From: [Sarah Hillis](#)
To: [ROG South East Region Mailbox](#); [Louis Cameron](#)
Cc: [Kyle Mercer](#)
Subject: RE: Blind Creek Solar Farm RTS - BMP and BDAR for comment
Date: Tuesday, 27 September 2022 3:31:00 PM
Attachments: [image001.png](#)
[image002.png](#)
[image003.png](#)
[image004.png](#)
[image005.png](#)
[Draft BMP BCSF BCD Comments NGH Response 20220926 MP.docx](#)
[image009.png](#)

Blind Creek Solar Farm

Biodiversity Management Plan August 2022 (BMP) Preliminary Comments

Figure 2 Environmental Management Zones for the proposed Blind Creek Solar Farm. Map 1 of 3.

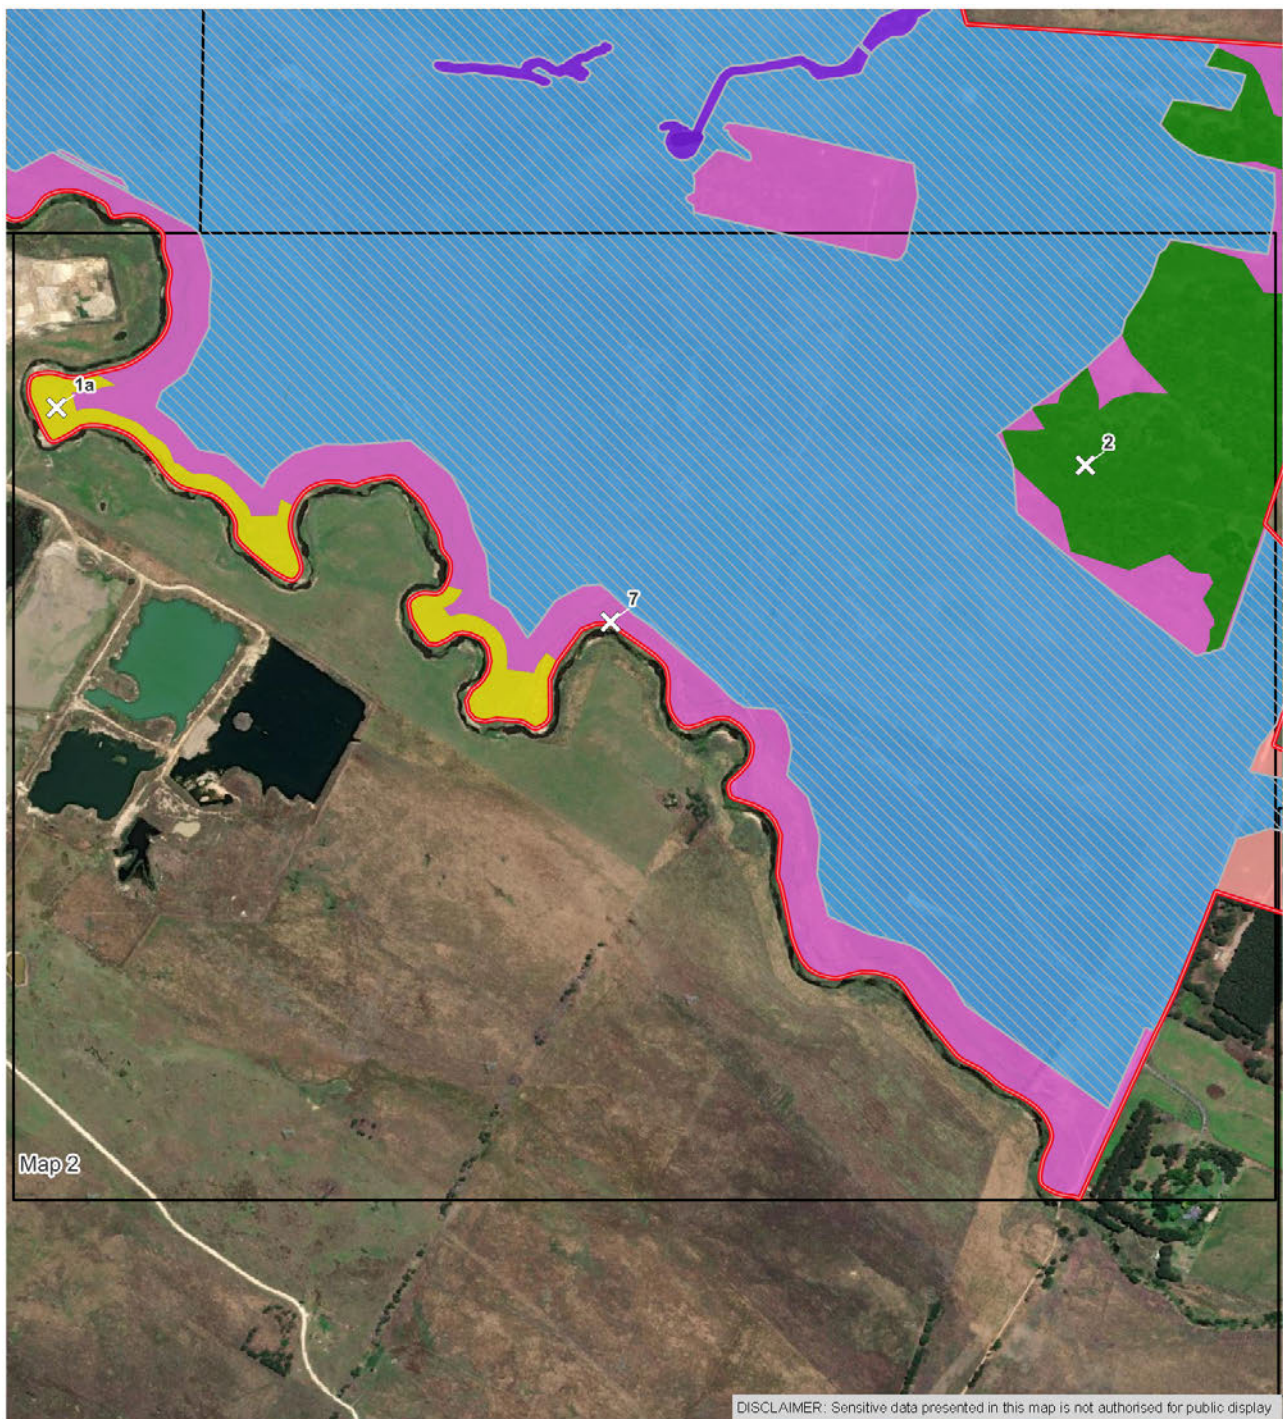
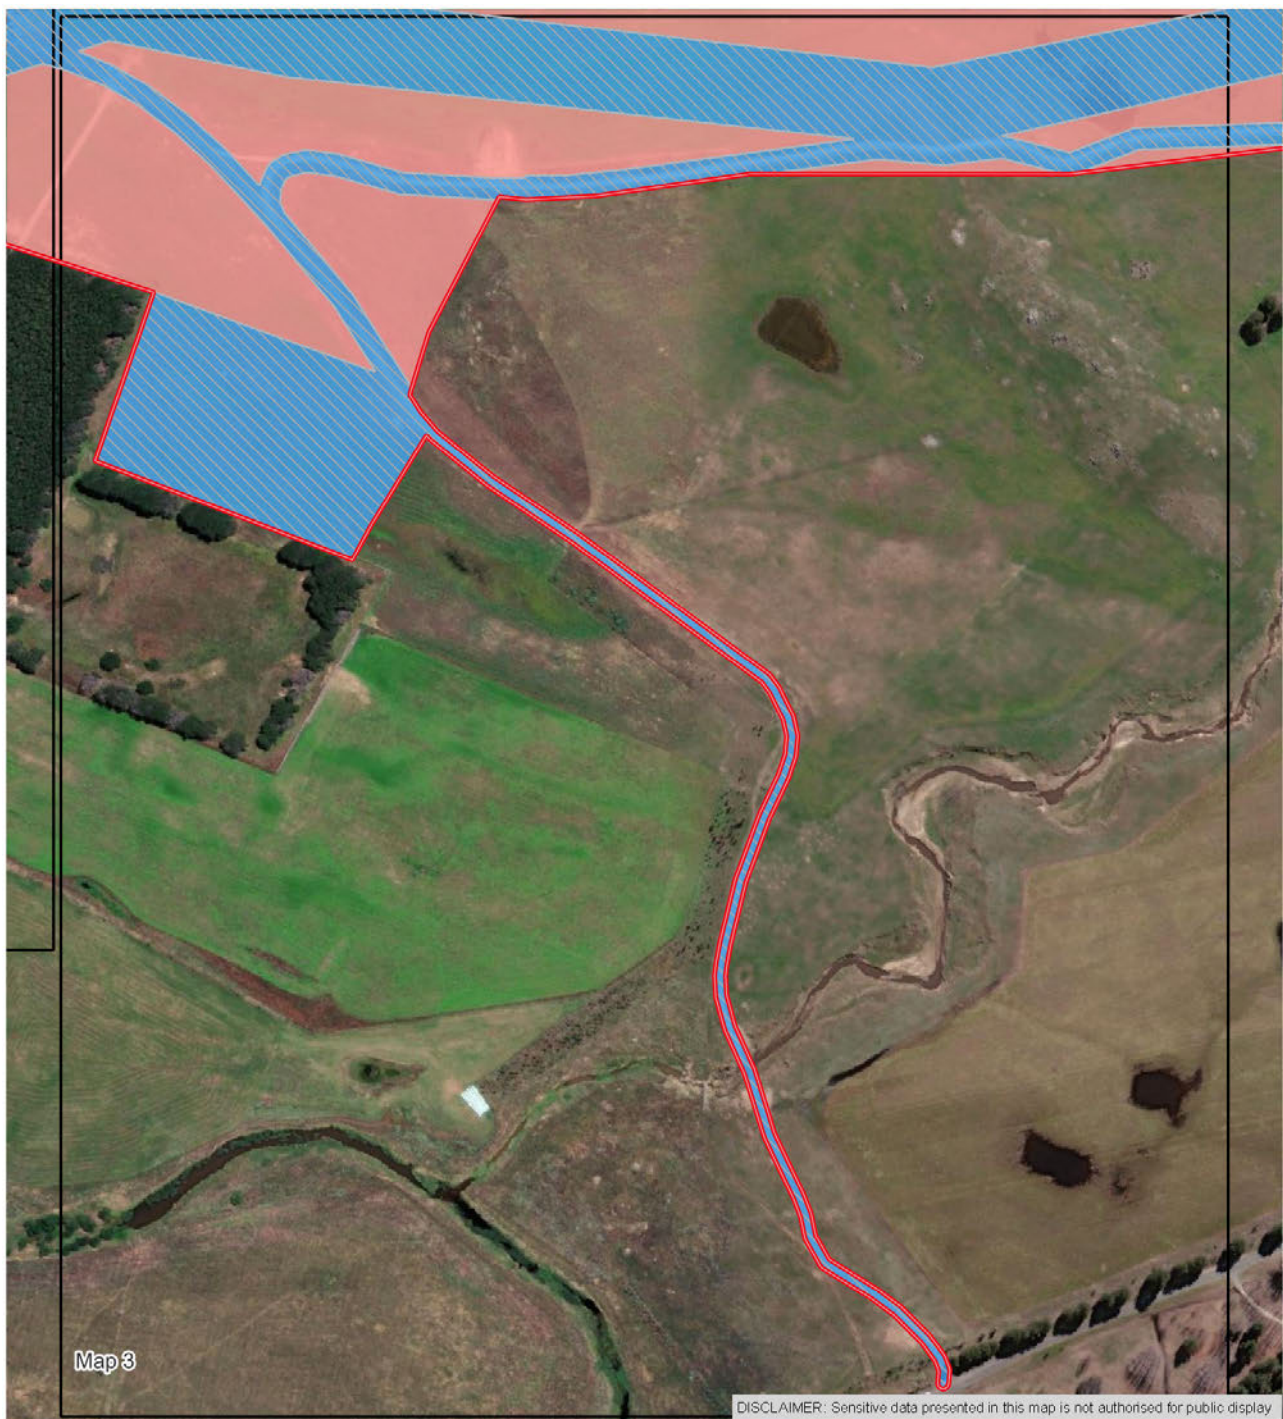
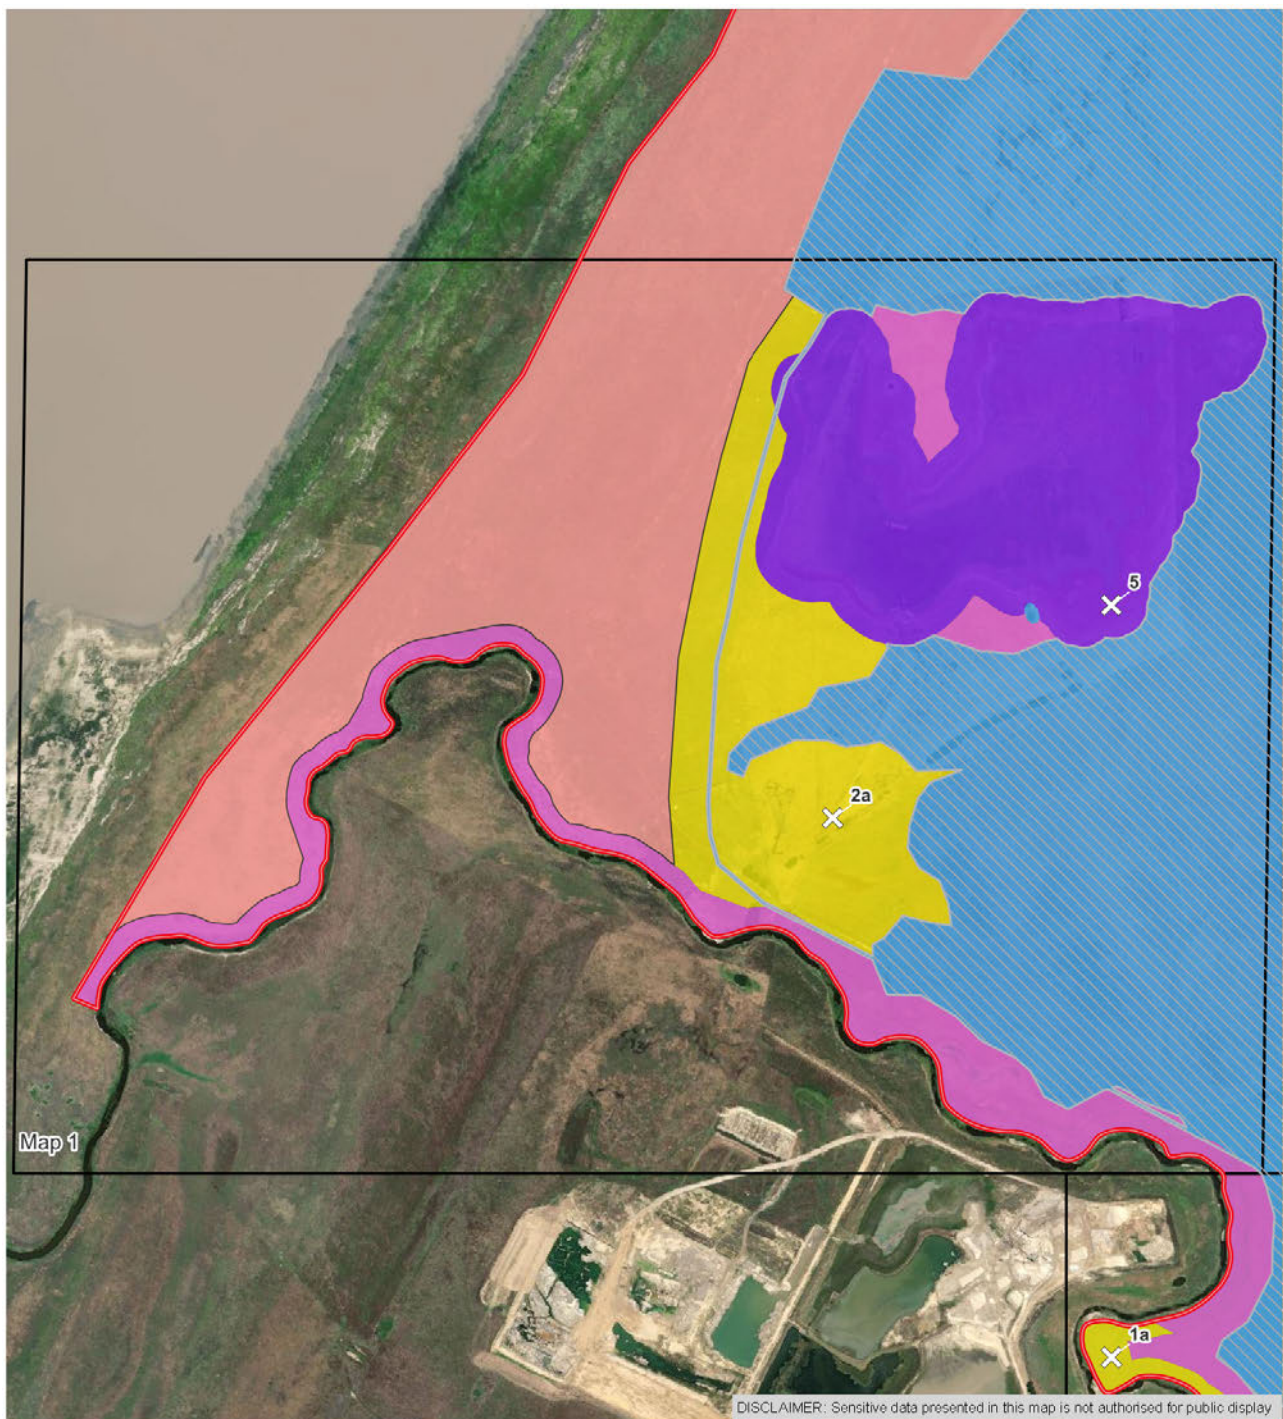
3.	<p>Detail management actions that would be applied to management zones to address threats. Identify the management zones on a site map. Identify and map any management zones which require different management actions. Suggested management actions include:</p> <ul style="list-style-type: none"> • Establishing dense plantings of indigenous species that support WFC breeding such as <i>Poa labillardieri</i>, prickly <i>Acacia</i> species such as <i>Acacia paradoxa</i>, <i>Bursaria spinosa</i>, <i>Leptospermum</i> and <i>Chenopodiaceae spp.</i> 	Detailed in 7.12.2 and Appendix K.	<p>Section 7.12.2 and Appendix K. updated with native species that occur in the area.</p> <p>Note: <i>Chenopodiaceae</i> species have not been recommended for planting as these species do not typically grow in the habitat identified within the development site.</p>
